### **Application by Chrysaor Production (UK) Limited for an Order Granting Development Consent for the Viking Carbon Capture and Storage (CCS) Pipeline**

#### **Request for Further Information**

9.34 DVSA Routing Options

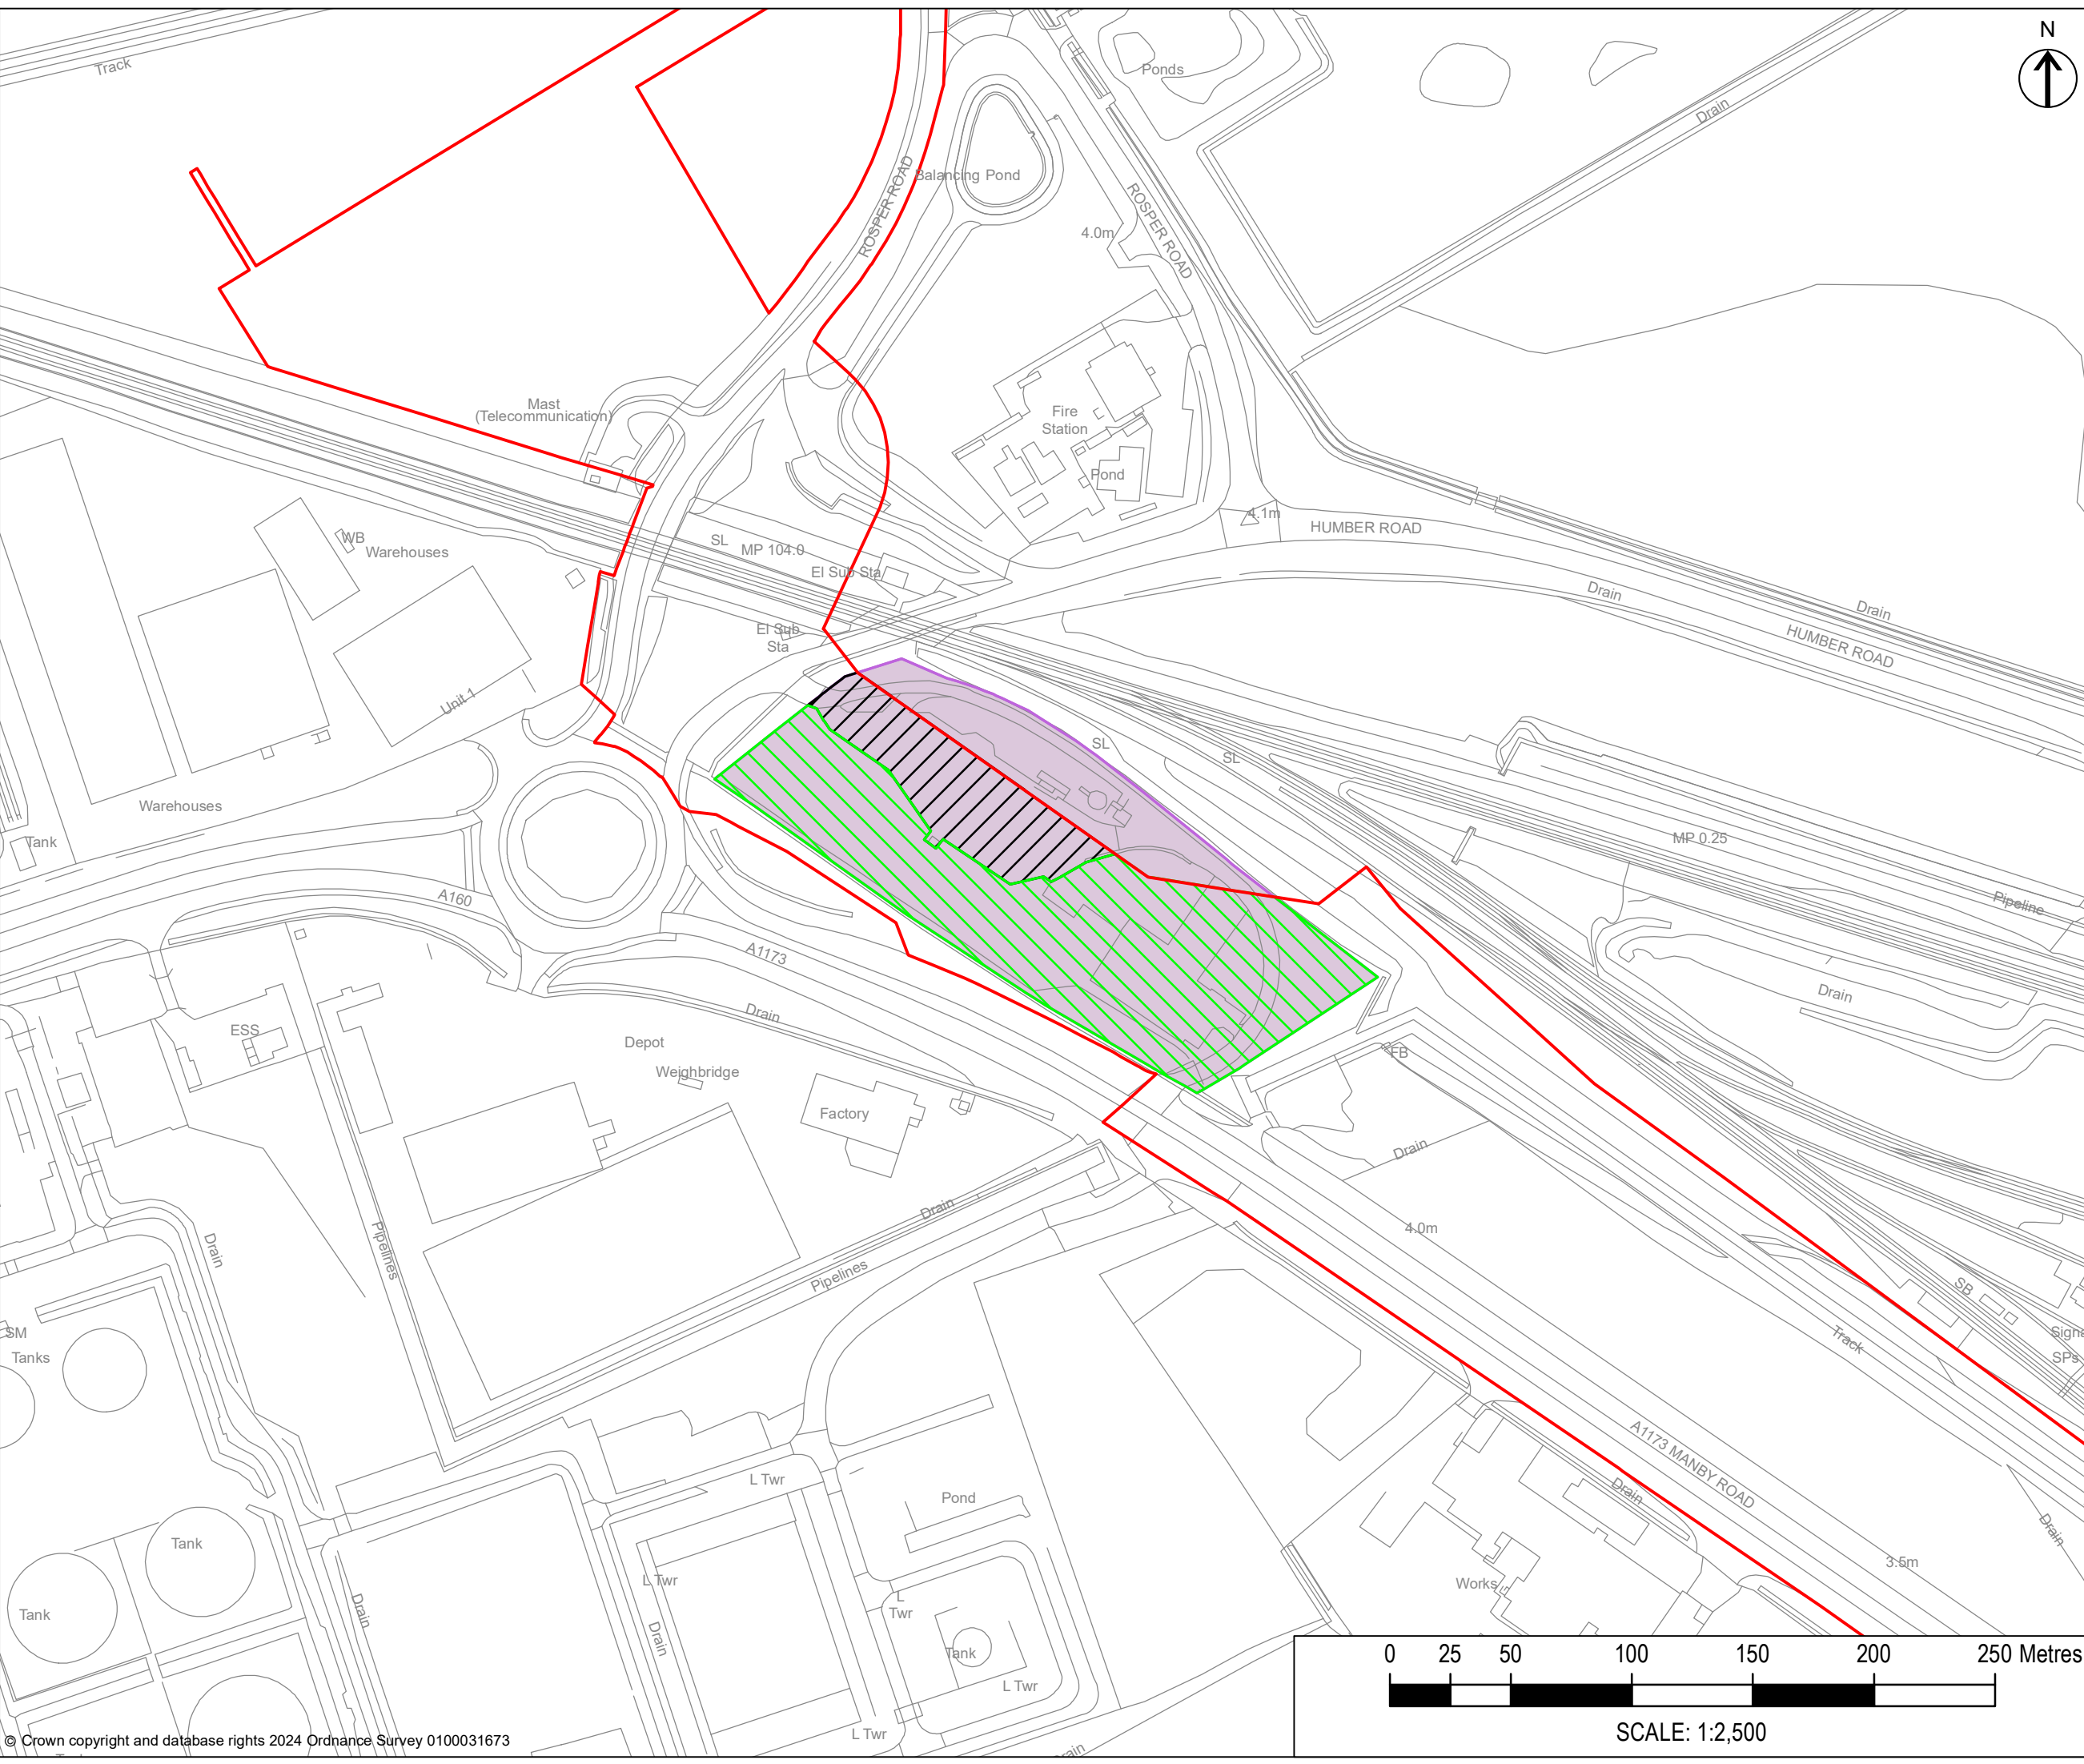
Having reviewed the submissions at Deadline 1 [REP1-045] [REP1-069] it would appear that there is a 'preferred' route going around the Drive and Vehicle Standards Agency (DVSA) commercial premises that would not entail any disruption to DVSA's operations and would not give rise to a need to relocate. The Applicant has however not ruled out the possibility of this and has stated that a 12-month notification would be given to the DVSA in the event that the pipeline would not be on the preferred route, to allow for relocation.

It is highly likely this issue may form part of the discussion at the Compulsory Acquisition Hearing to take place in June 2024 [PD-009]. To better inform the ExA, please provide a map/diagram showing a) the Order limits, b) the DVSA site in full, c) the operable yard areas of DVSA that, if interfered with would result in a relocation being necessary and d) the 'preferred route' of the pipeline that would avoid conflict with DVSA's operations. Please provide this information by **Deadline 3 (11 June 2024)**.
